Minor Subdivision Responses to Comments

DATE SUBMITTED: 11/28/2022
REVISIONS:

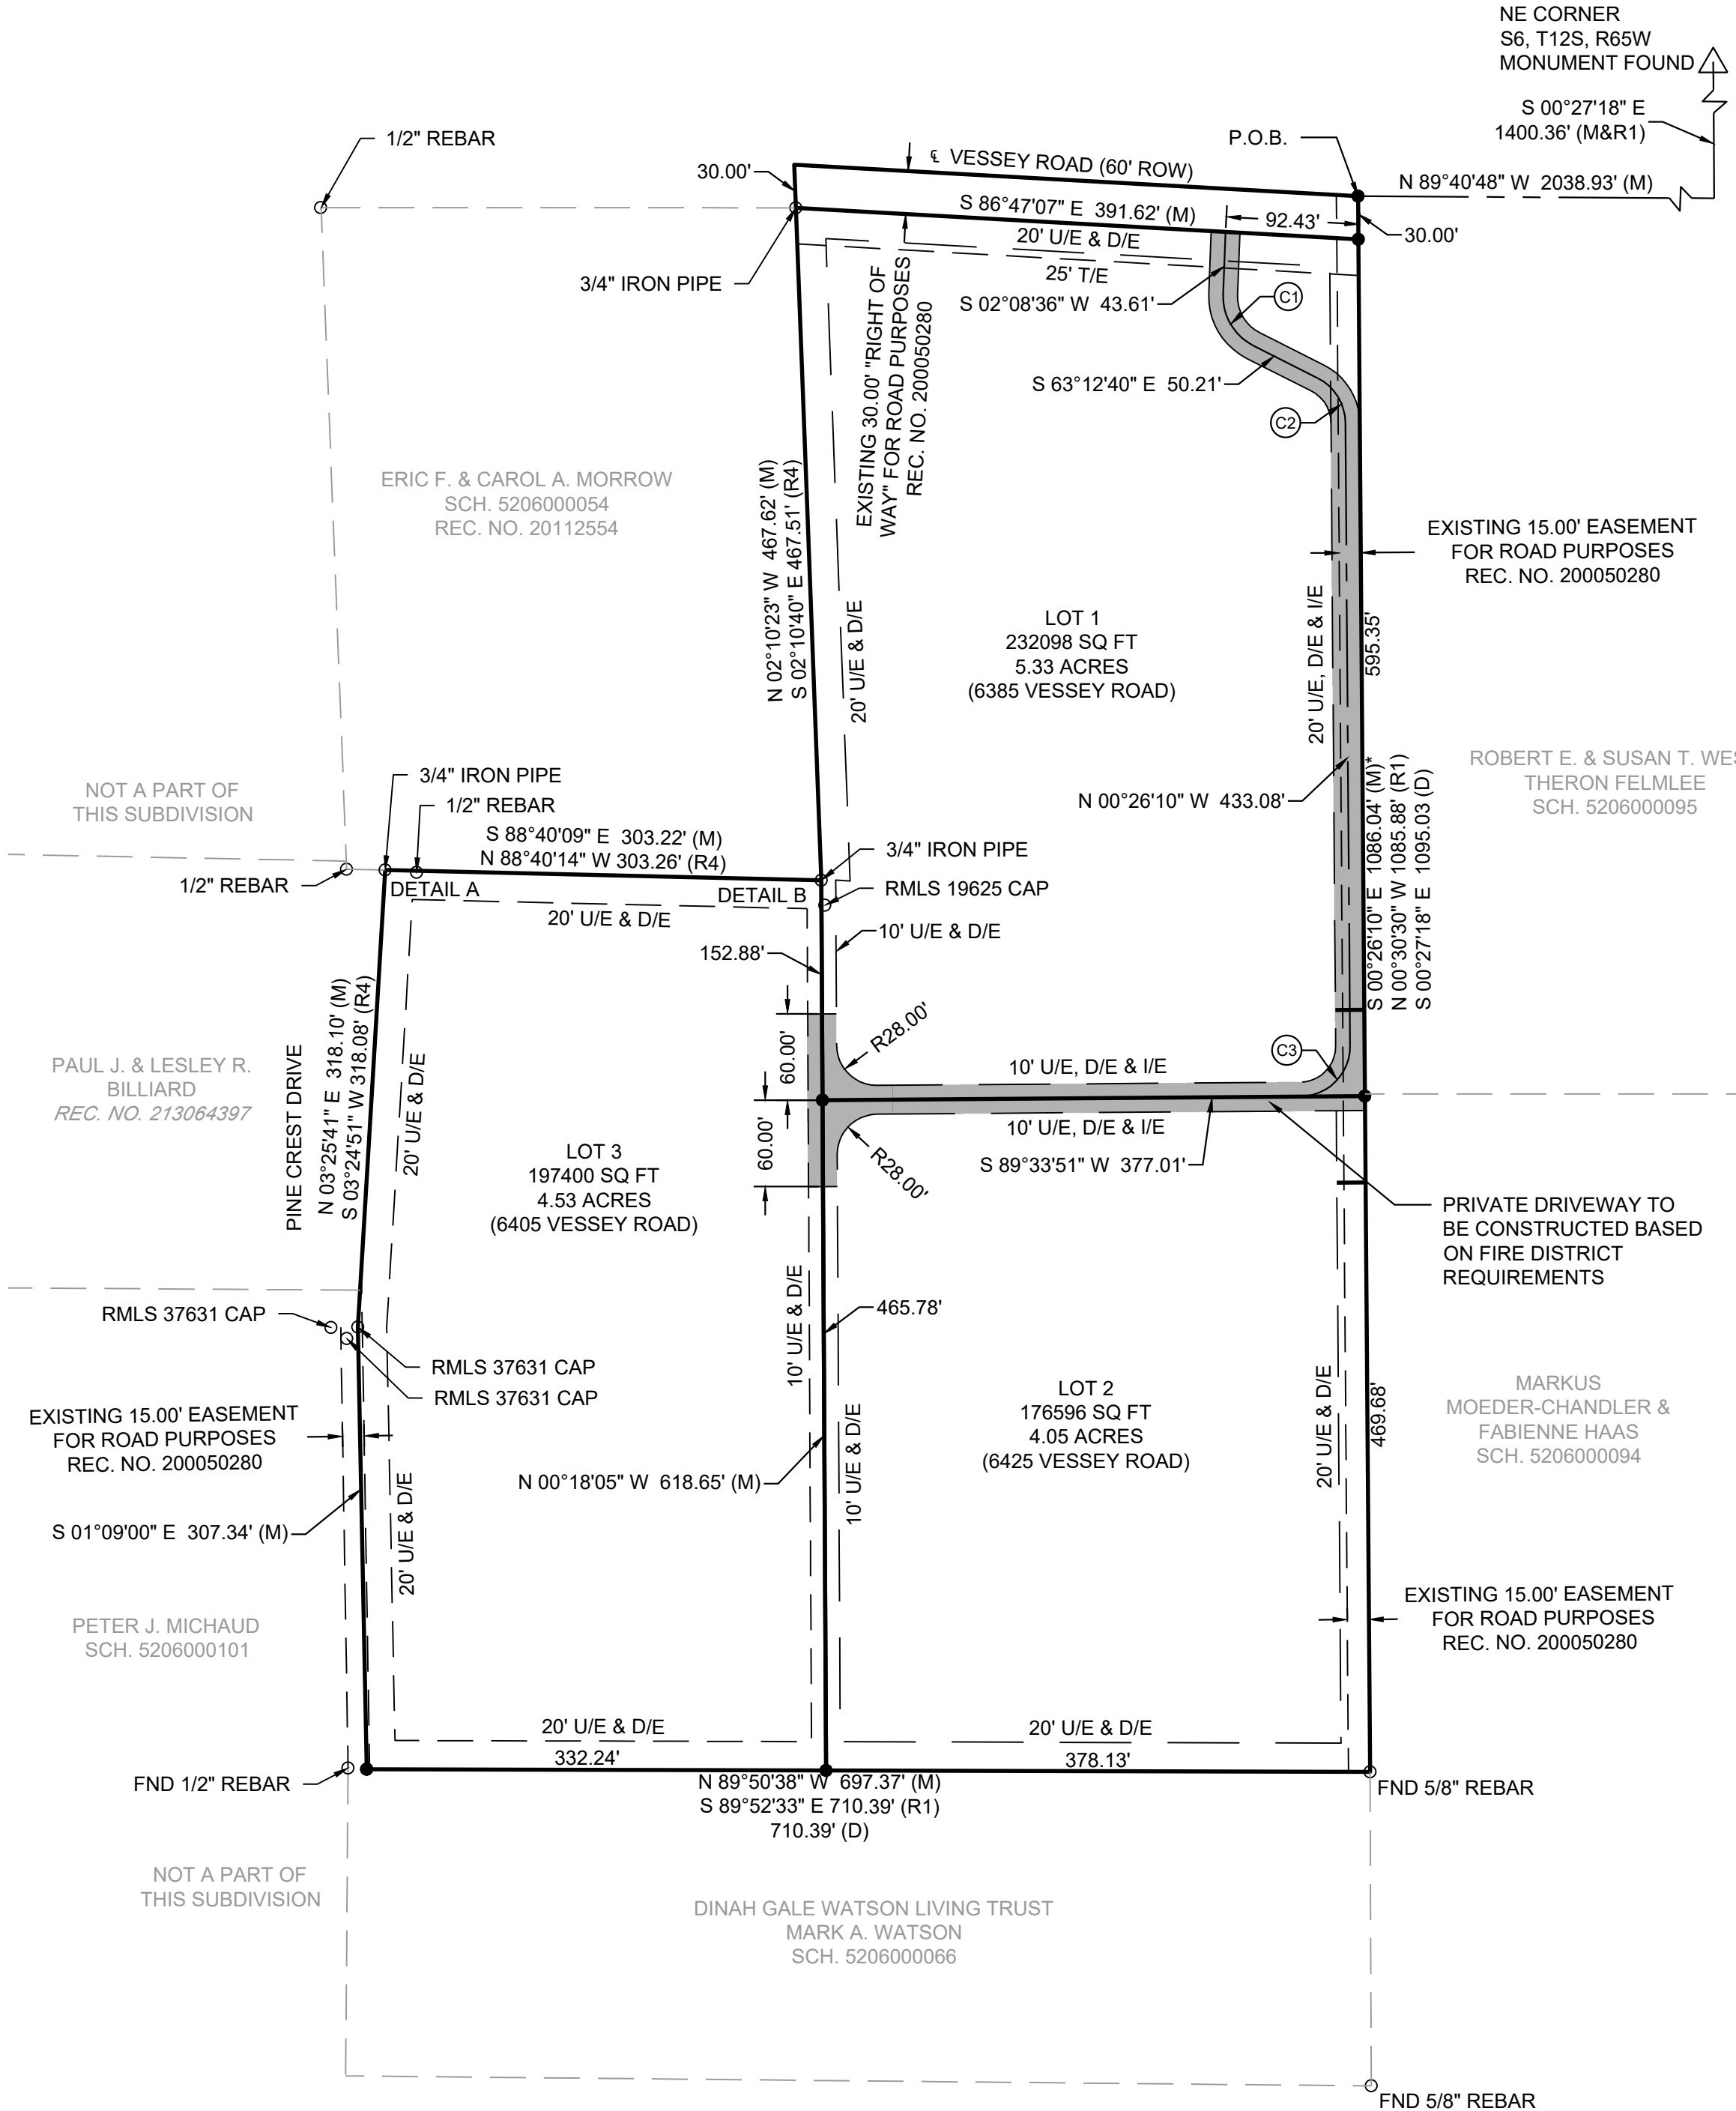
- **Final Plat:**
 - Add ROW width 60 ft. **Label has been updated.**
 - Review and verify if these were intended to be easements or ROW dedicated to El Paso County. If these were intended as ROW then subdivision/lot property line should be adjusted to not include these areas. If these are easements then revise the label. **Updated on plat**

- Correct to reception #200050280. **Label has been revised.**
 - The 15 ft. ROW widths should be reflected as easements not ROW. **Updated**
 - The I/E width does not meet the international fire code criteria and should be widened (see below). However, coordinate with the fire district regarding their requirements for the access driveway width and turnarounds. See Land Development Code Section 6.3.3.C.3 for additional criteria. **I/E width updated on plat.**

- Adjust corner of I/E to accommodate driveway design criteria noted in LDC 6.3.3.C.3 (see below). **Updated on plat**
 - Update plat to show R². **R² callout removed from legend.**

- Place the pond in a drainage easement if it's remaining in place. If this is a stock pond then add the following note: "Notice: Future property owners are advised that El Paso County's approval of this plat does not include certification of water rights or the structural stability of the existing pond located on the subject property. The State of Colorado has jurisdiction regarding modification or elimination of the pond". **State of Colorado DWR was contacted regarding the existing stock pond. DWR found no record of this being an approved structure under their jurisdiction and recommends removal of the structure. Applicant will coordinate with the Colorado Dam Safety Engineer for what is required to remove the structure. Notice has been added to plat.**

- Please check all lot sizes against sq. ft. indicated 4.5 ac is 198,020 sq. ft. **Lot square footages and acres have been updated accordingly.**
 - Add a blank space to write the reception number. **Space has been added.**

- Add PCD file #MS-22-08. PCD File Number has been added.
- Show the above easements on plat drawing and label. **Added to plat**
- Private drives and streets shall be labeled as such and shall include assignment of maintenance responsibility. **Private driveway labeled. Maintenance responsibility outlined in the access maintenance agreement submitted with this application. Note referencing this document is also included on the final plat.**
